Re: 9701 Central Ave Parking Lot Drainage Report
Engineer's Stamp dated 9-5-02 (K20/D53)

**RE: 9701 Central Ave. Parking Lot
Drainage File K-20/D-53**

Parking Lot Addition

at 9701 Central Ave. NE

SHEET NO.
C1

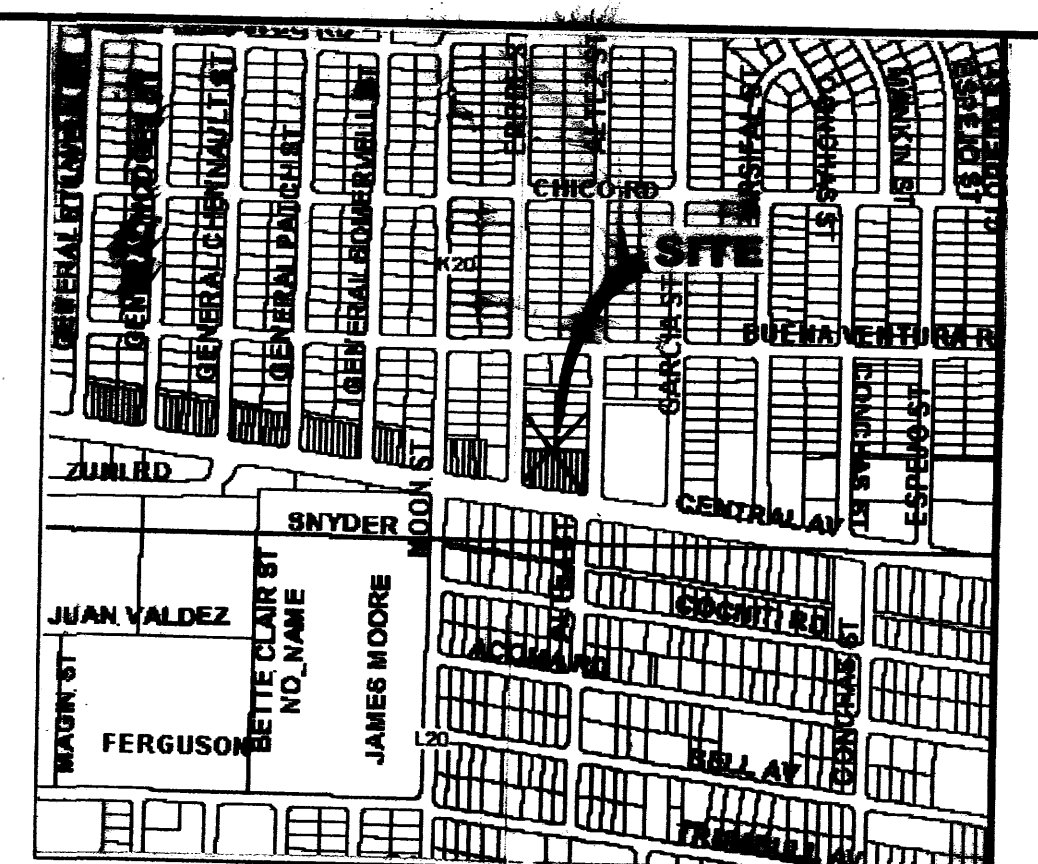
Based upon the information provided in your submittal dated 4-21-00, the above referenced report cannot be approved for Paving Permit and SO#19 Permit for the following reason. It is my belief that the increase in runoff generated by your project will not impact the downstream facilities enough to warrant breaking the curb for the outlet pipe of the proposed pond (that may not be maintained to the City's satisfaction anyway). Therefore, please provide a plan that describes free discharge and an excerpt of the downstream facilities. The storm drain for this basin starts at Ventura and General Patch and connects to the Lomas system at Wyoming.

Based upon the information provided in your submittal dated 9-5-02, the above referenced report is approved for Paving Permit and SO#19 Permit. Please attach a copy of this approved plan to the construction sets prior to sign-off by Hydrology.

Per your letter of August 15th, and our subsequent conversation, the plan has been revised to indicate free discharge to the street west of the site. As we discussed, the discharge could occur via a drivepad or via a sidewalk culvert. There are no existing or planned drivepads in the vicinity of the discharge point, so I called out a new sidewalk culvert at that location.
